OUT17/26809

**Rocky Hill Coal Project (SSD 5156)**  
**Comment on the Response to Submissions RTS**

Mitchell Isaacs  
**Director, Planning Policy & Assessment Advice**  
 30 July 2017

Figure 2.29.10
Year 0.5

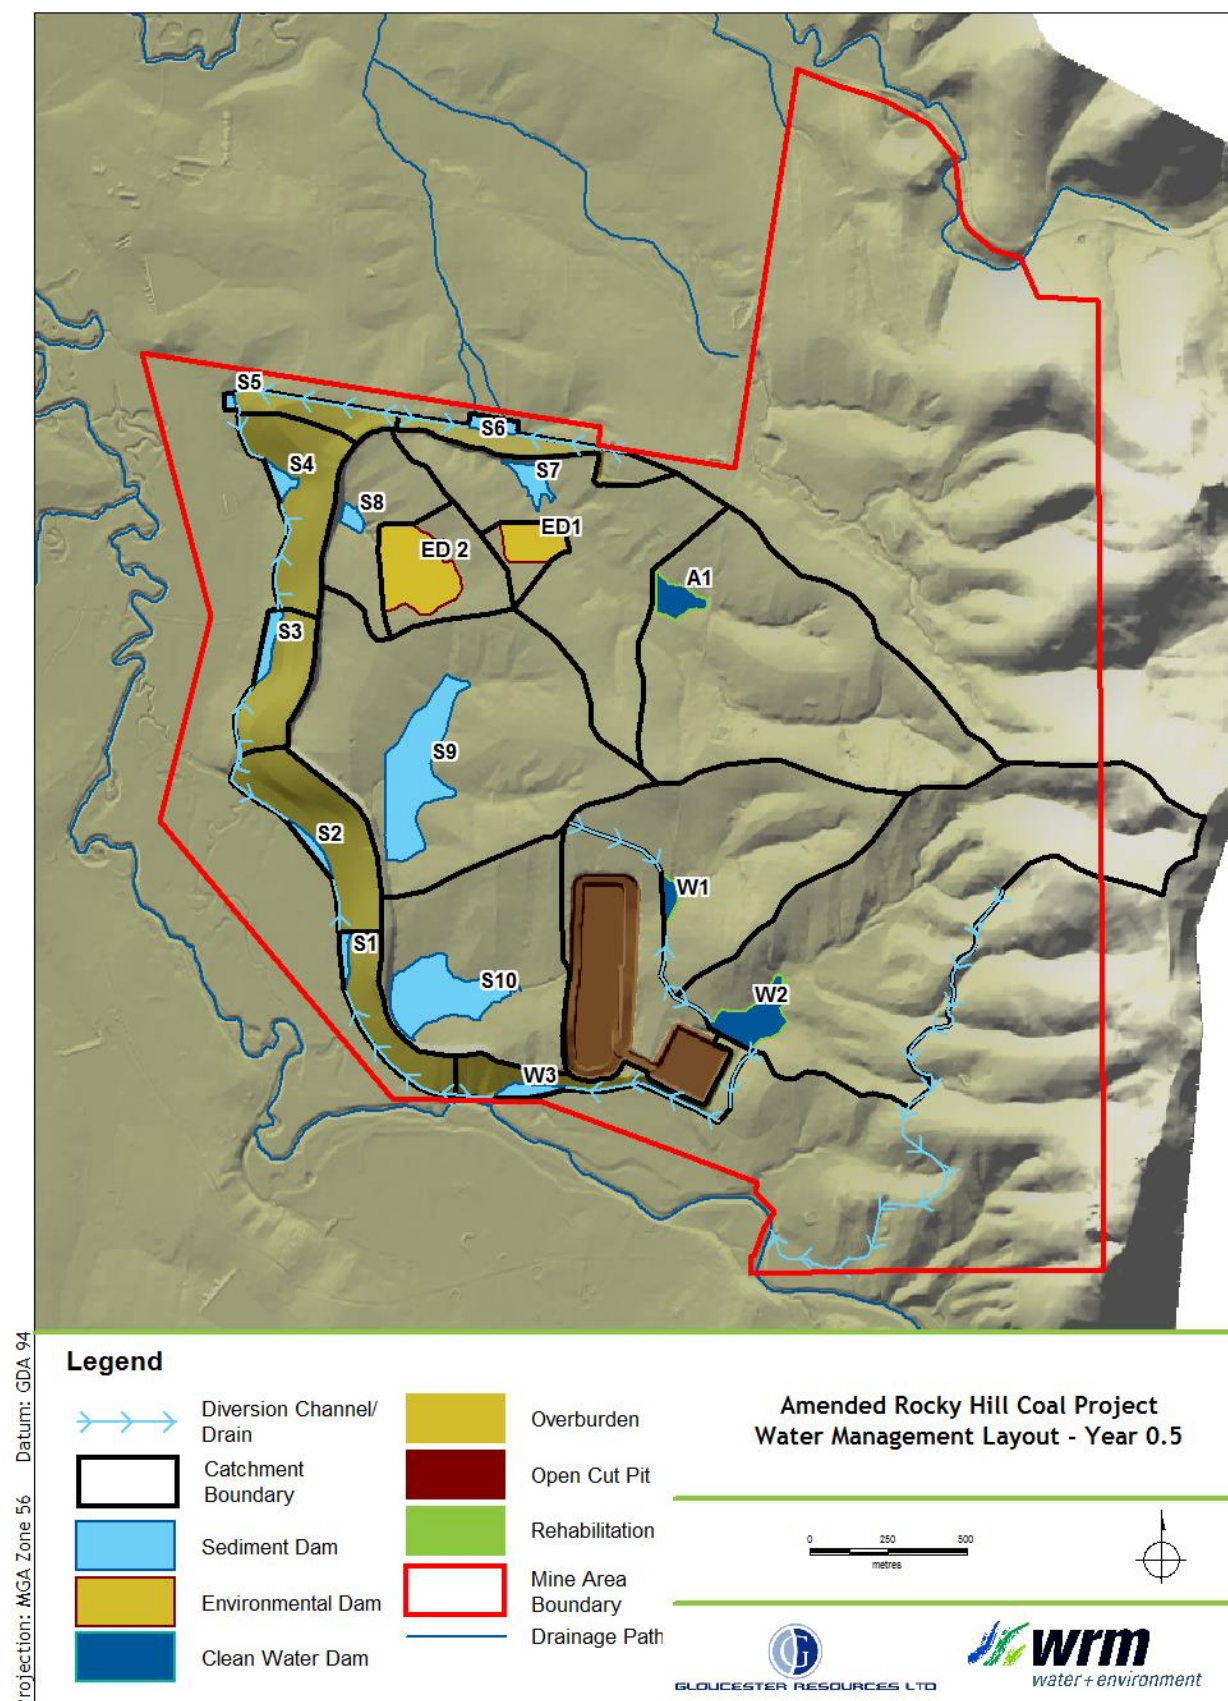
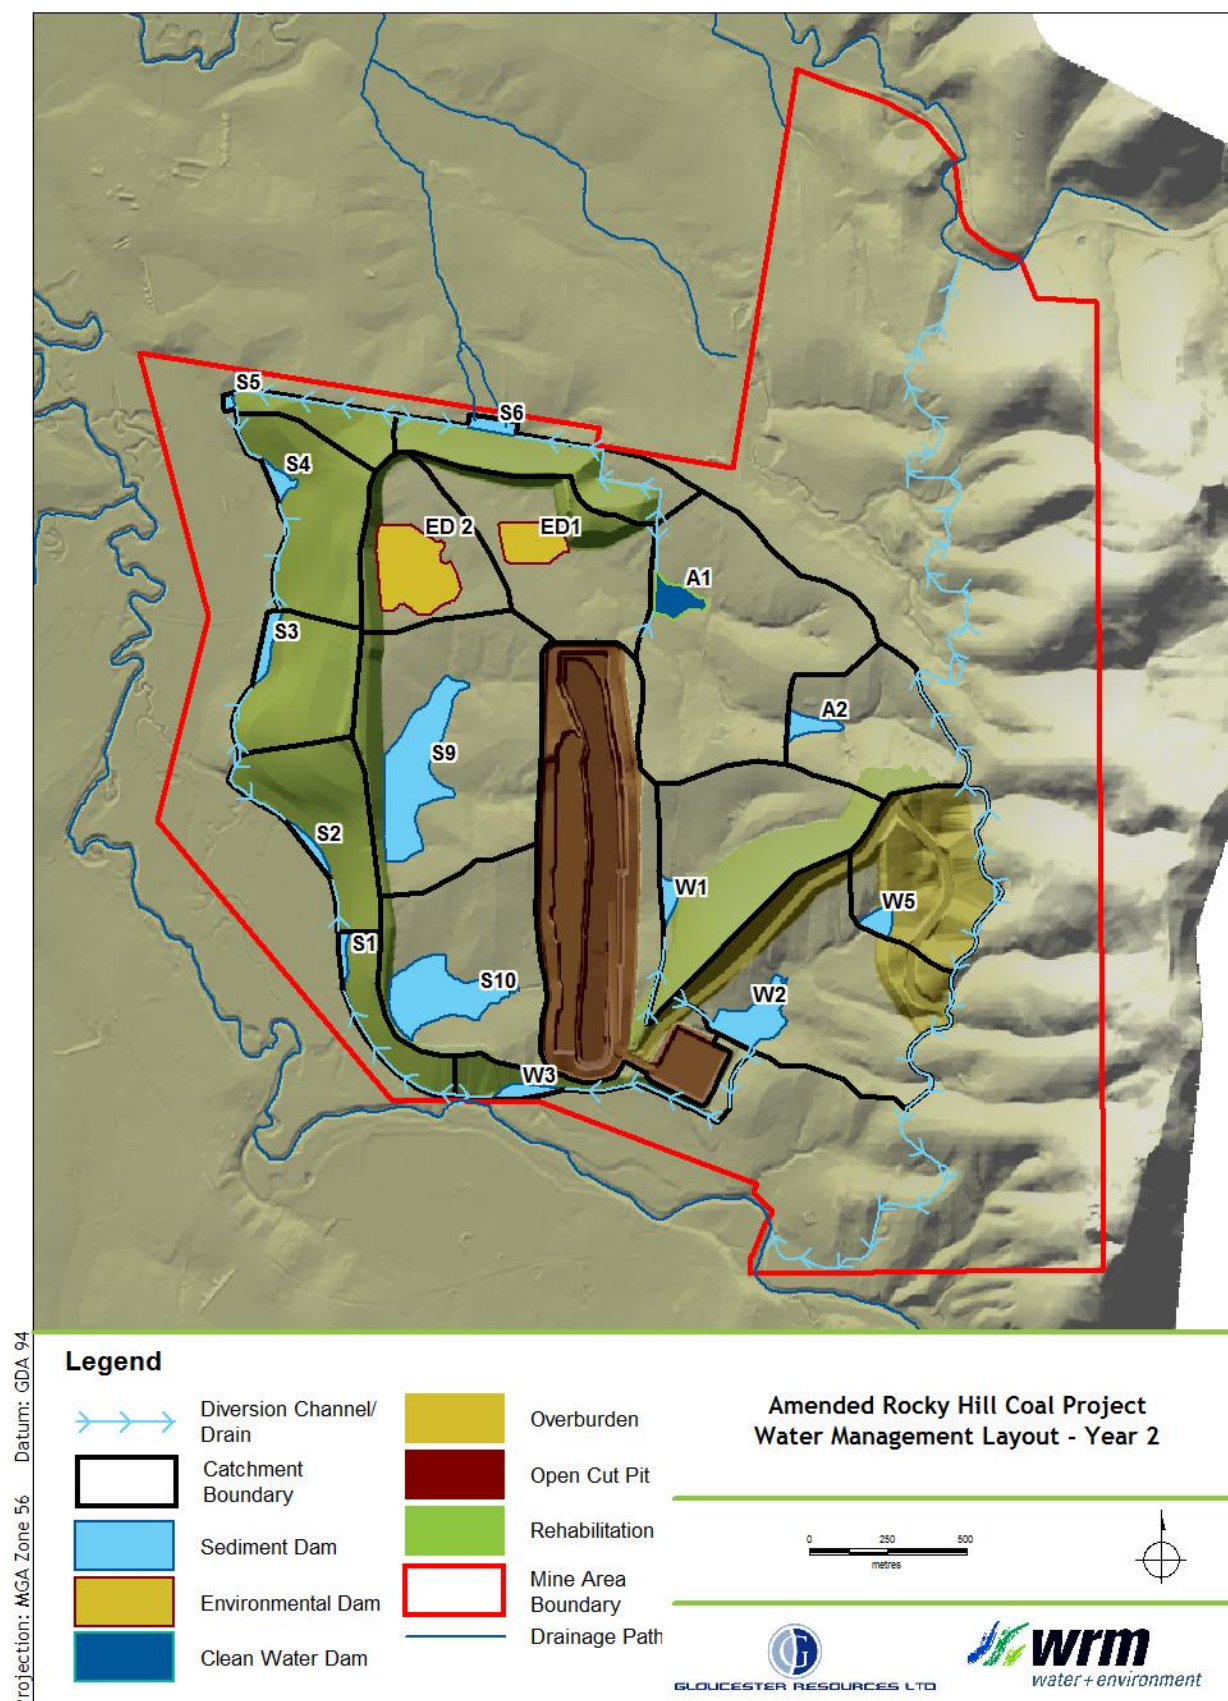
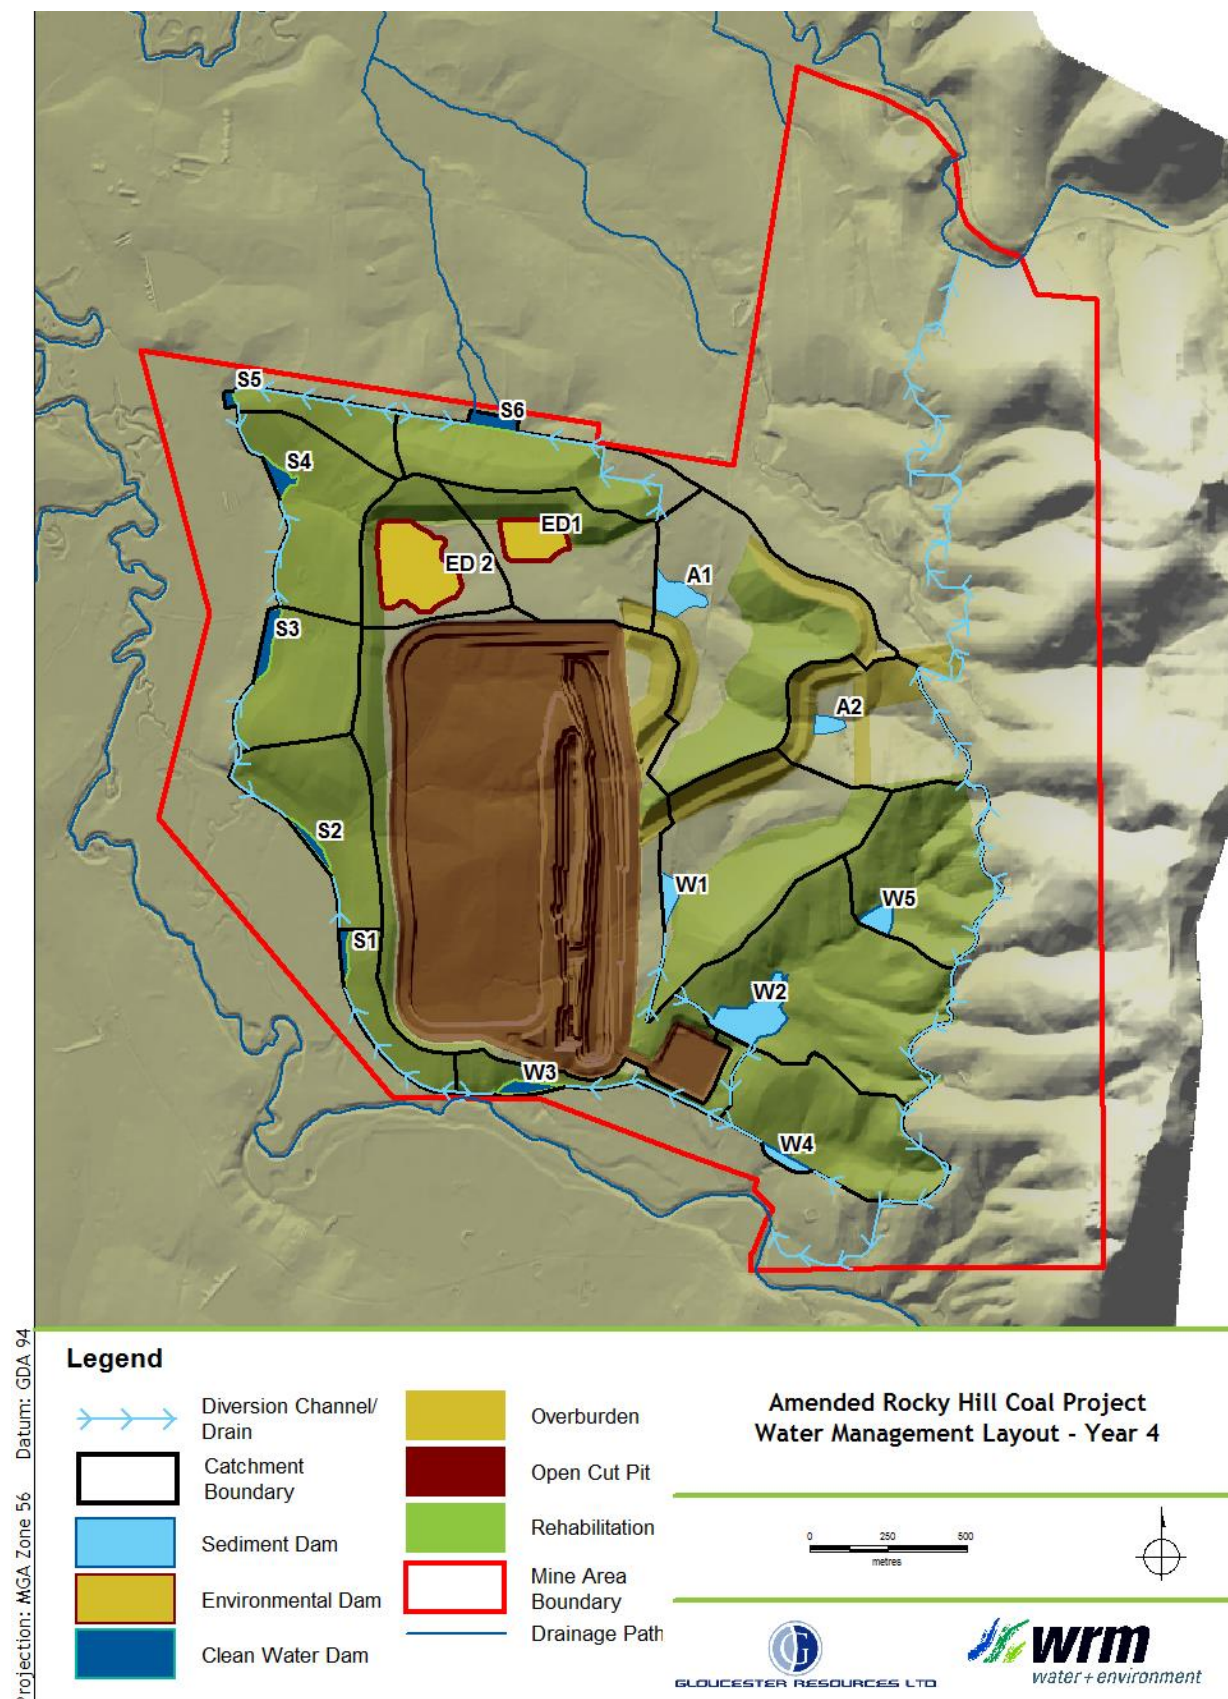
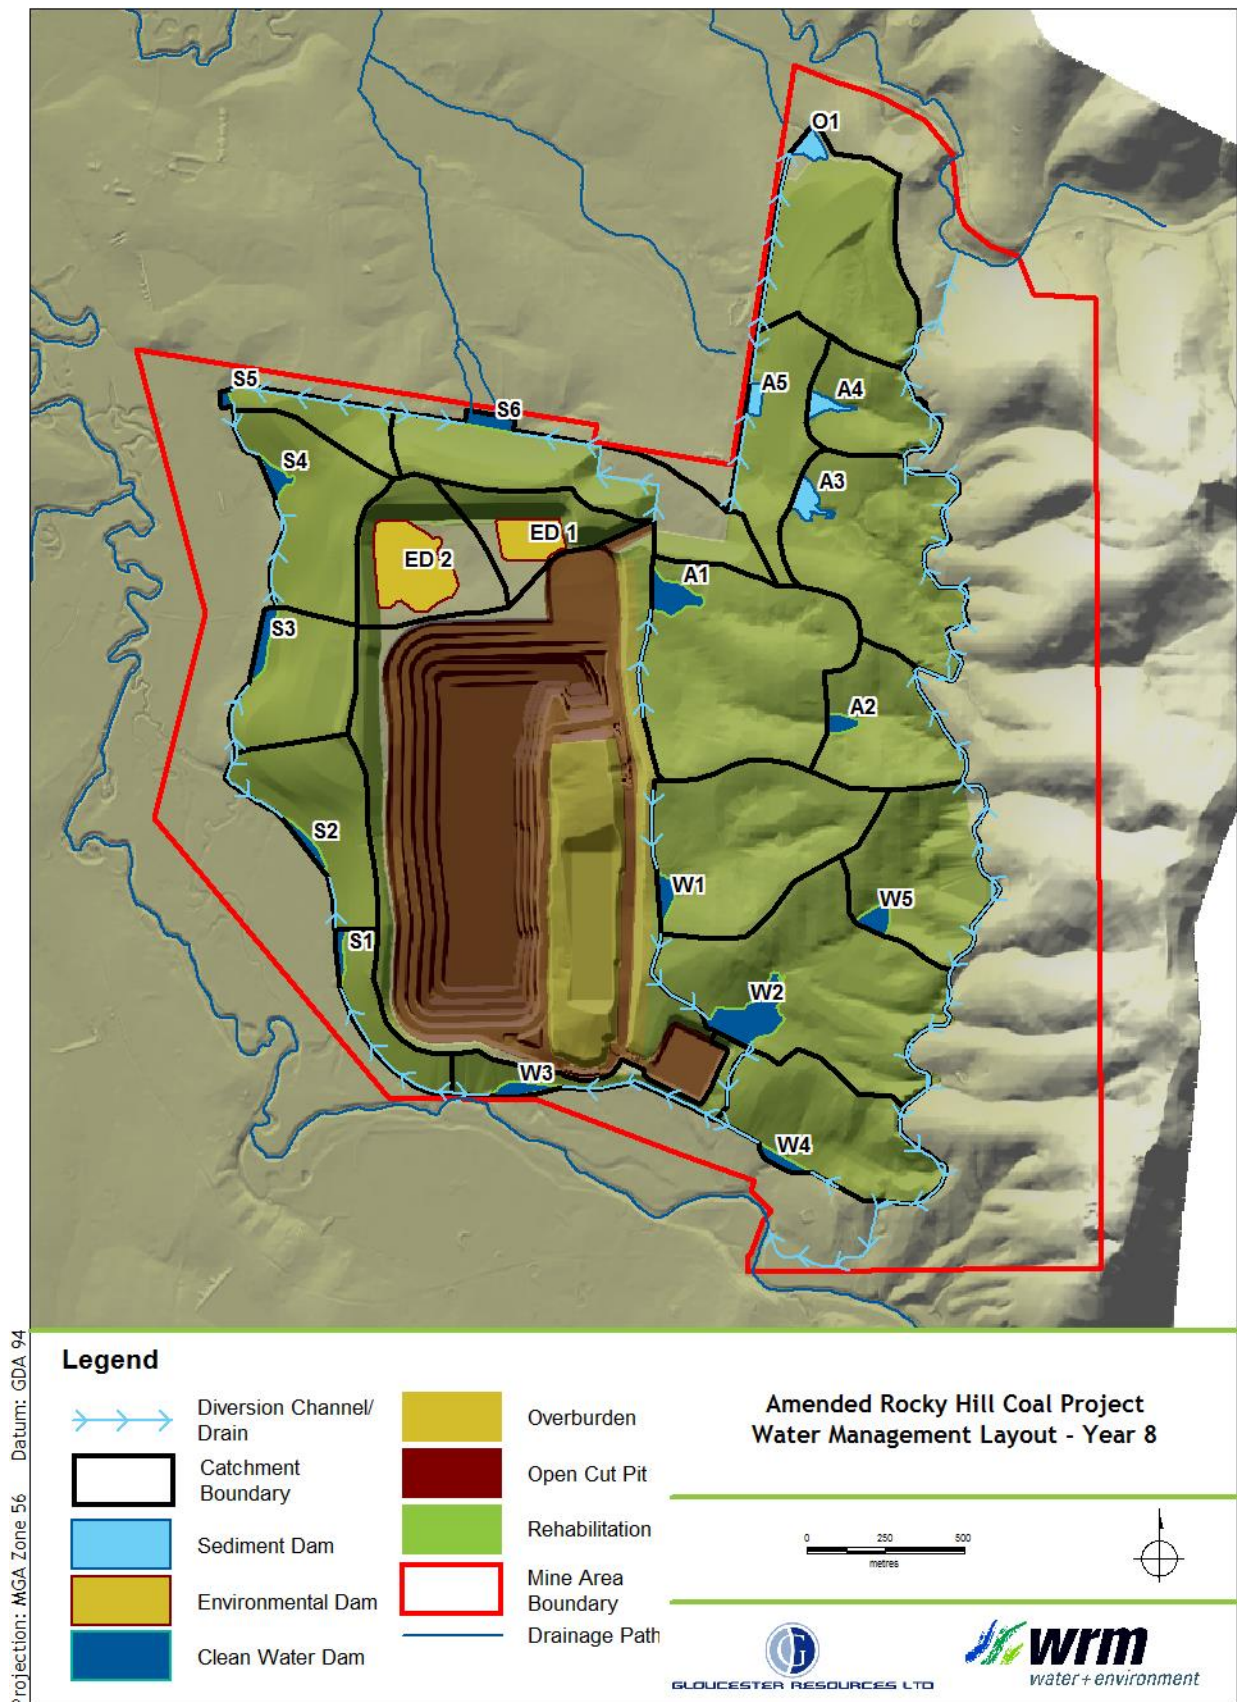
- The proponent should provide detailed information regarding the proposed catchment changes and shares required for dams S2, W2 and W3. It is noted that these dams are to be constructed on 3<sup>rd</sup> order streams however due to diversions will be 'effectively turkey's nest dams'.
